From: Michael Eastham
Sent: 31 January 2019 16:07
To: Planning.Responses
Subject: FW: Walberton - Today's Development Team Meeting

Please upload the email from ADC Drainage and the attachments onto Ocella for WA/95/18/RES – Land East of Tye Lane, Walberton.

From: Laura Gibbons
Sent: 31 January 2019 12:02
To: 'Laura Humphries'
Cc: Michael Eastham
Subject: RE: Walberton - Today's Development Team Meeting

TYPICAL CELLULAR SOAKAWAY DETAIL
(1:20)

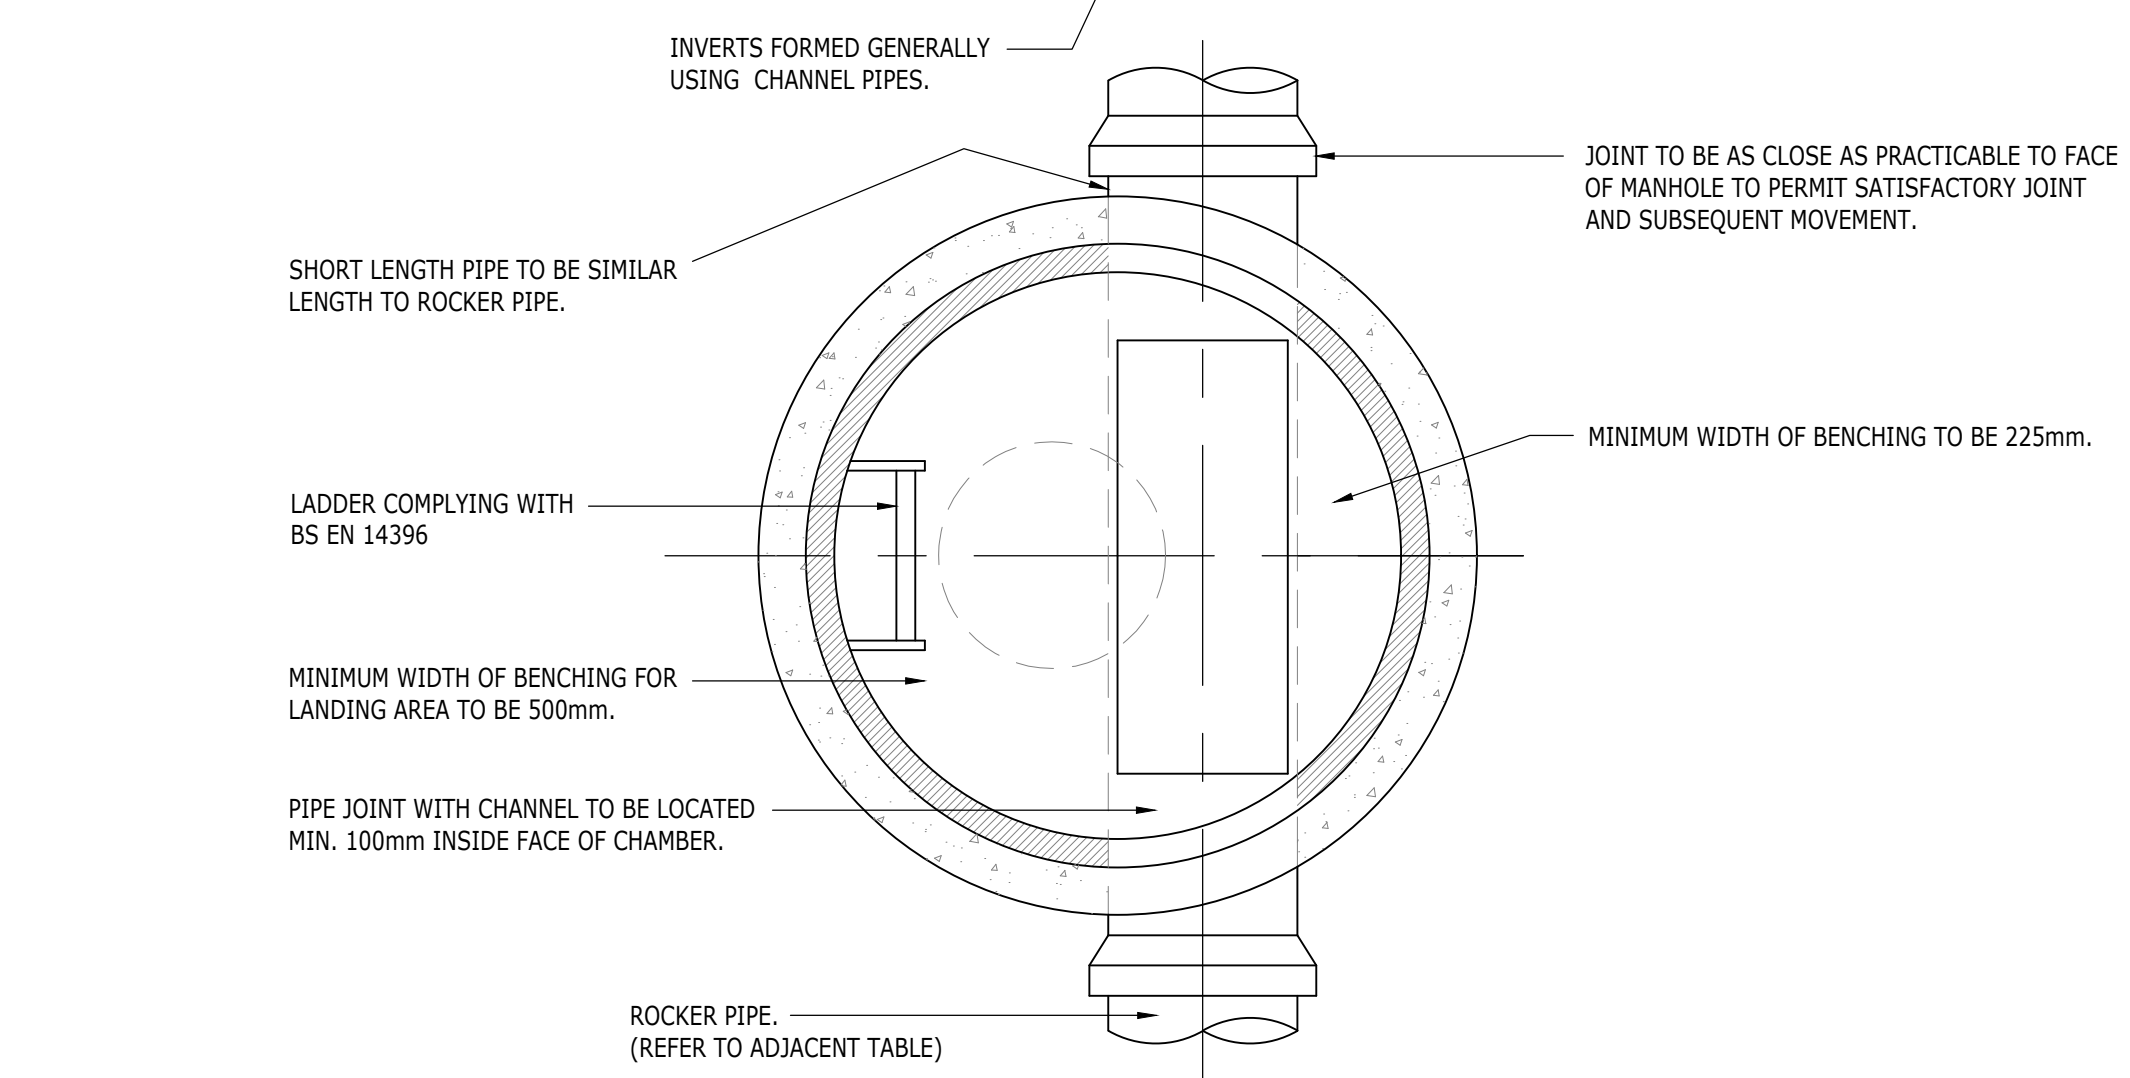
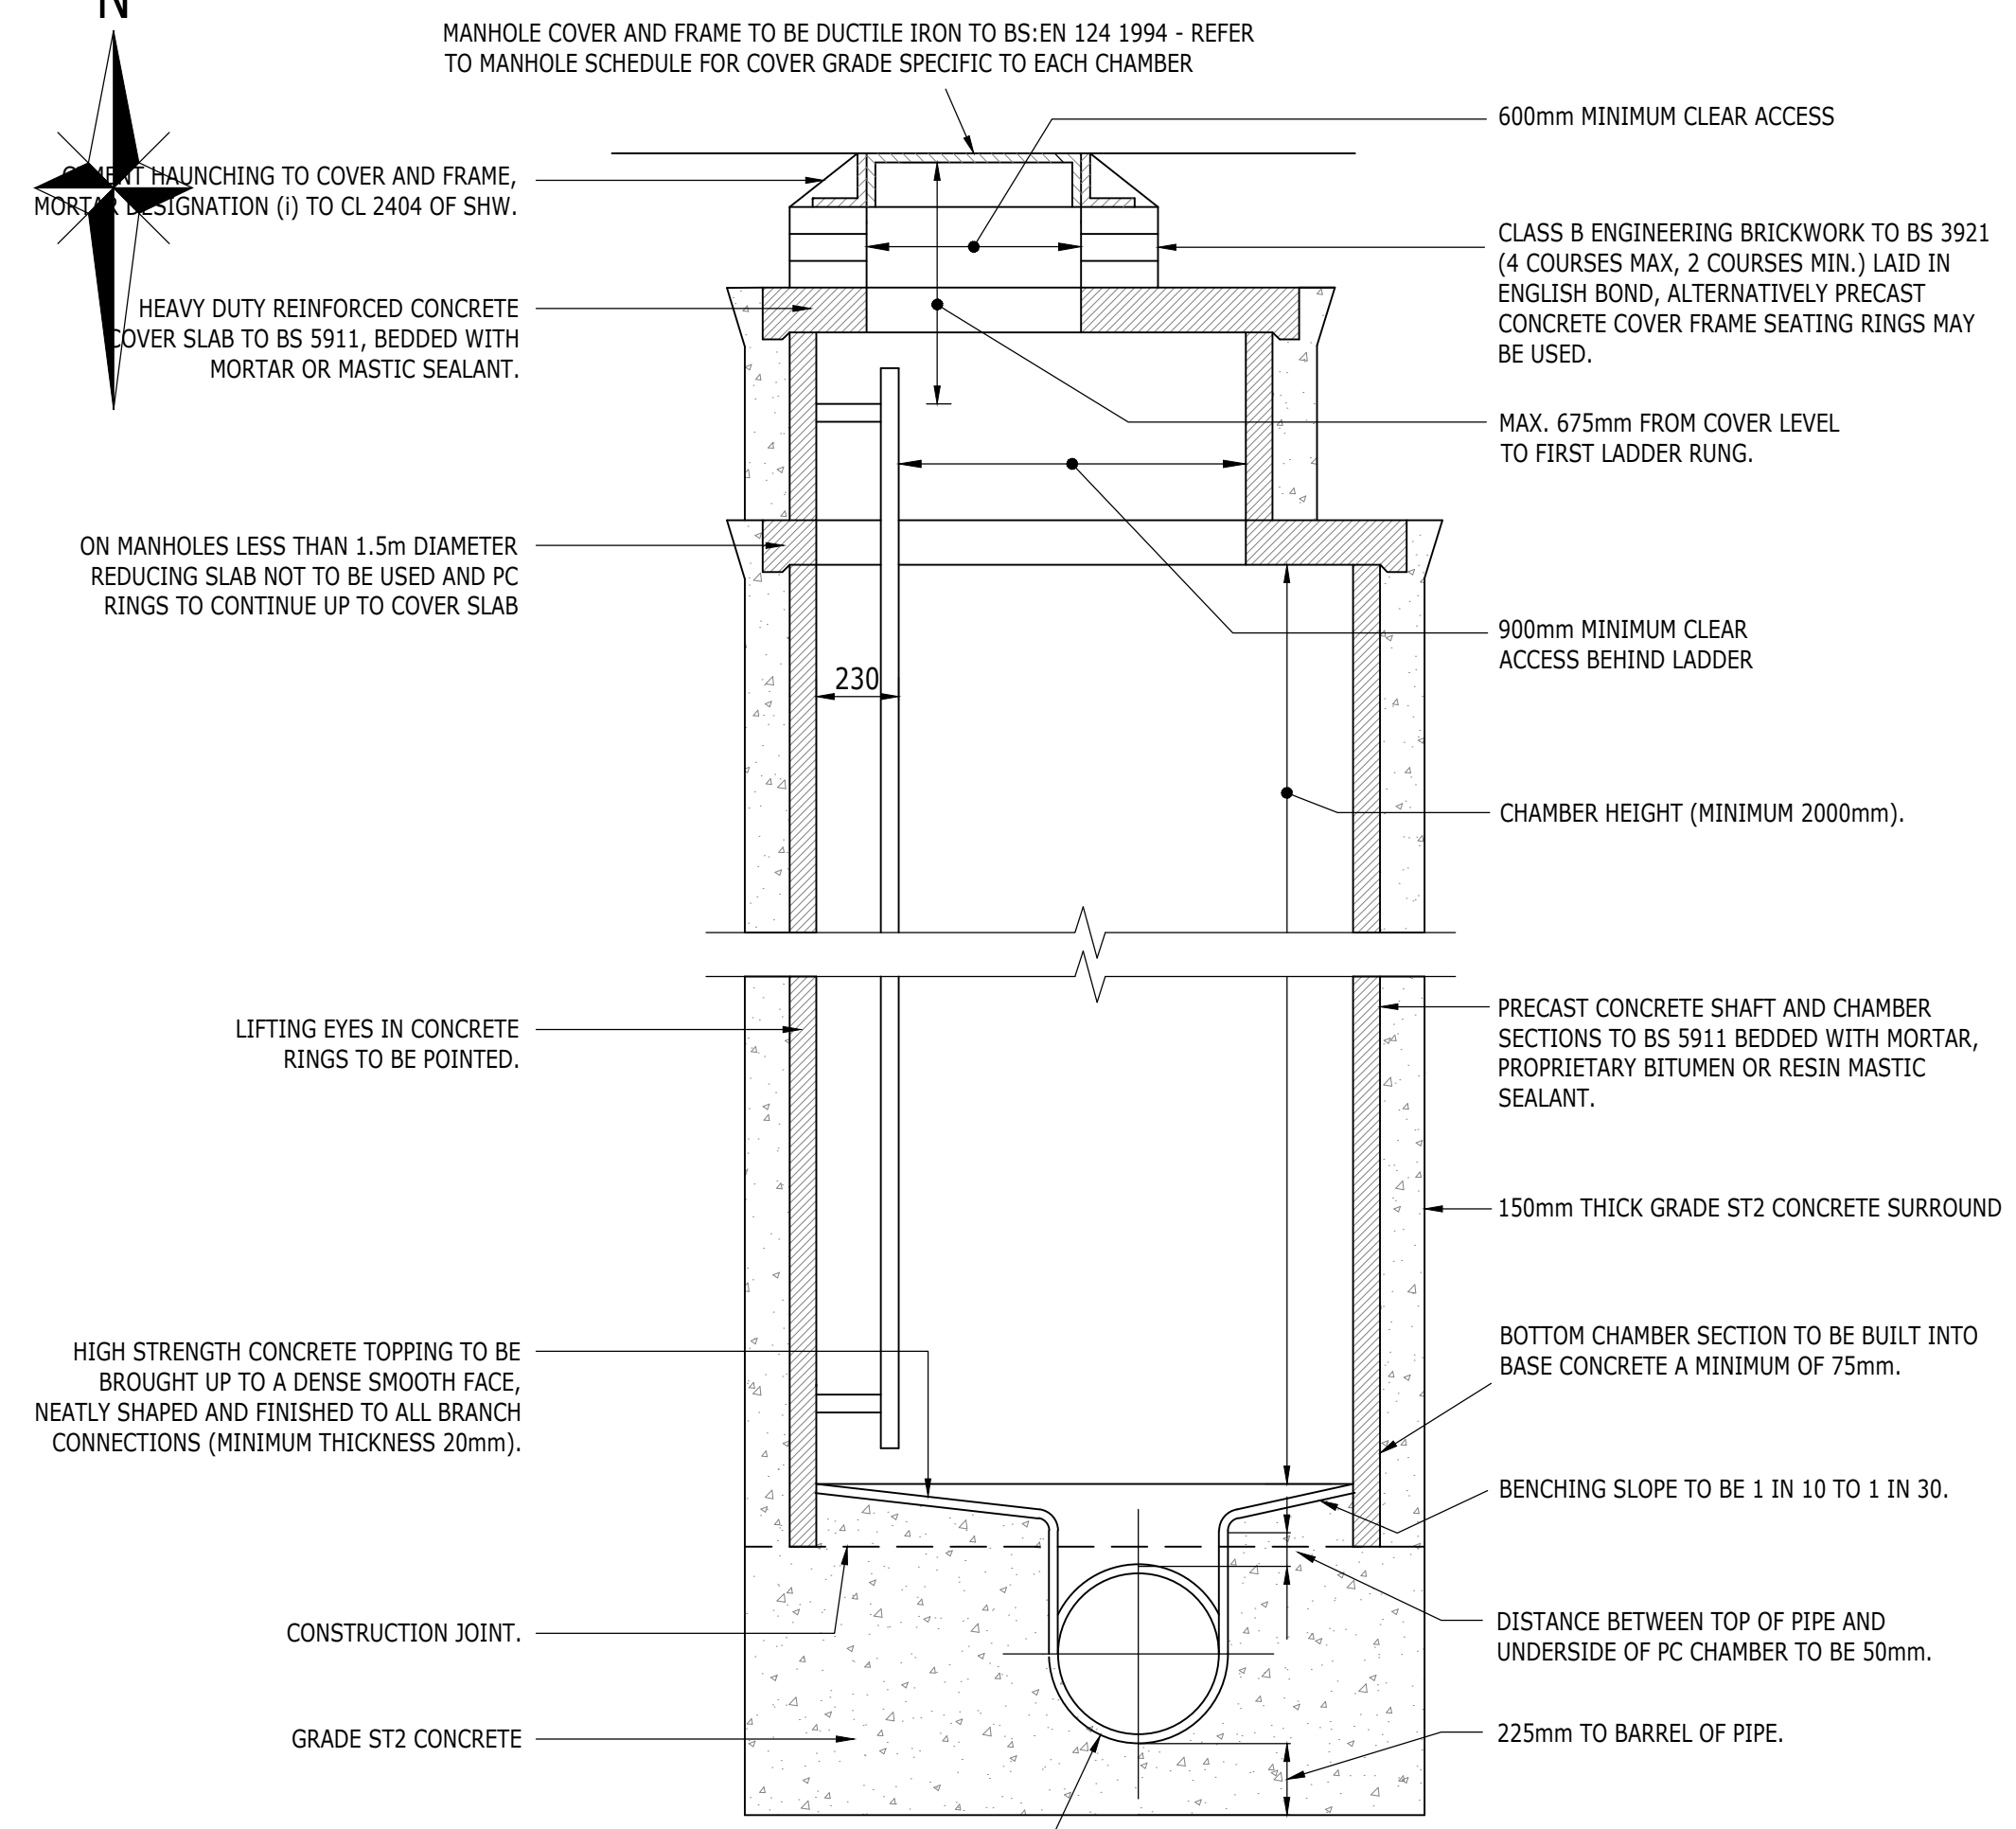
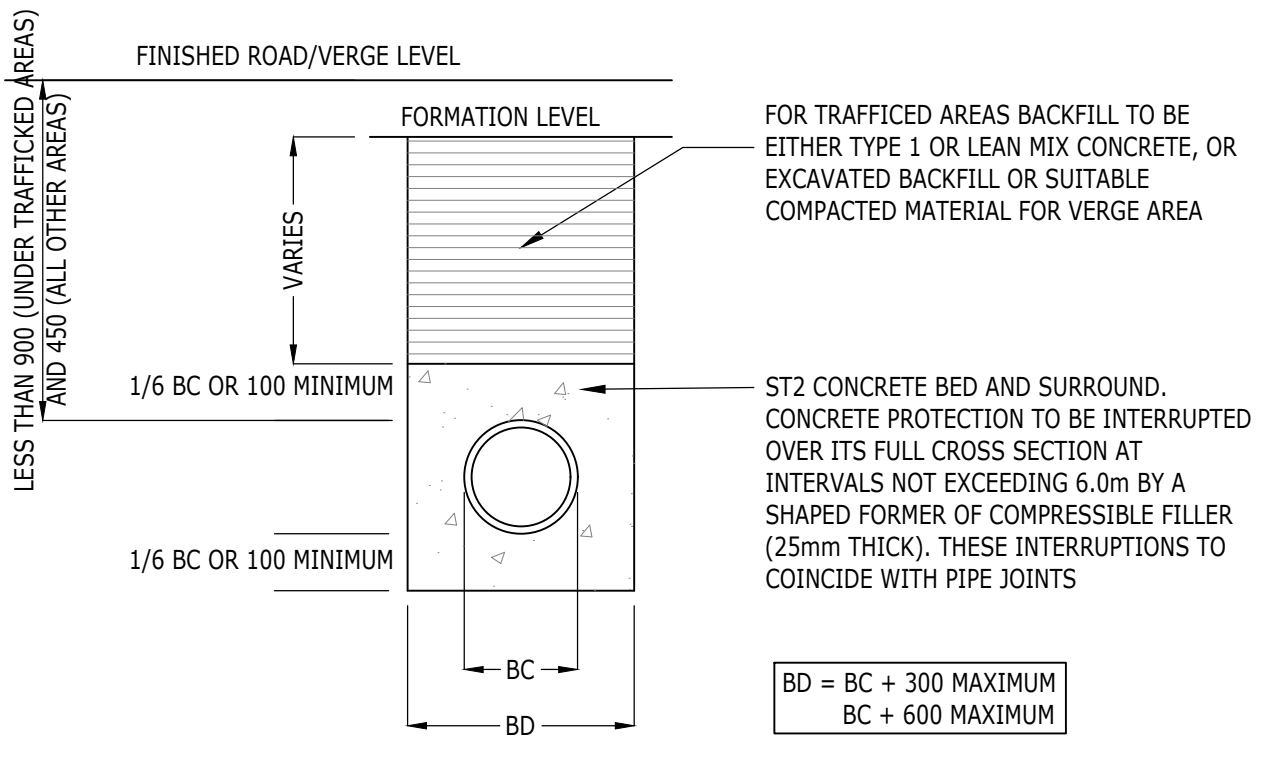
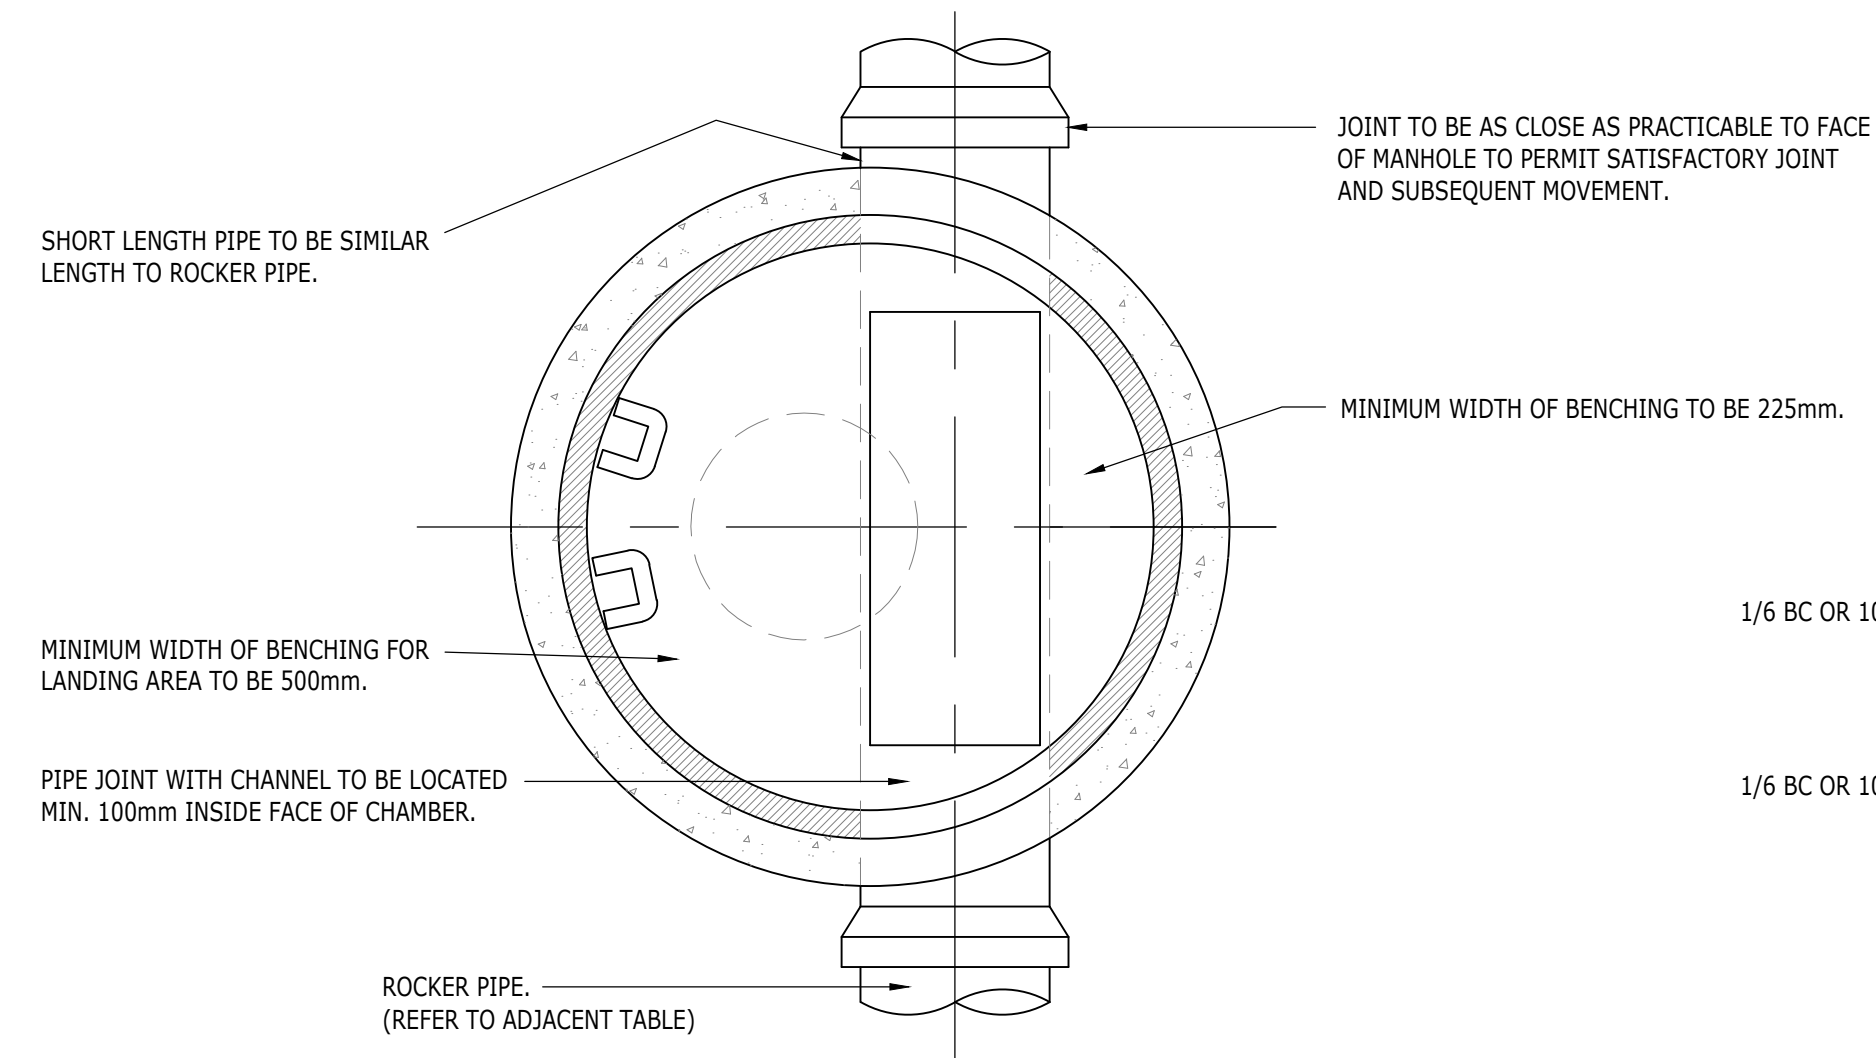
14. Permeable paving construction details need to show permeable geomembrane fully wrapping around the subbase.
15. All other construction details must be provided with the DOC application, not just reference to Sewers For Adoption.
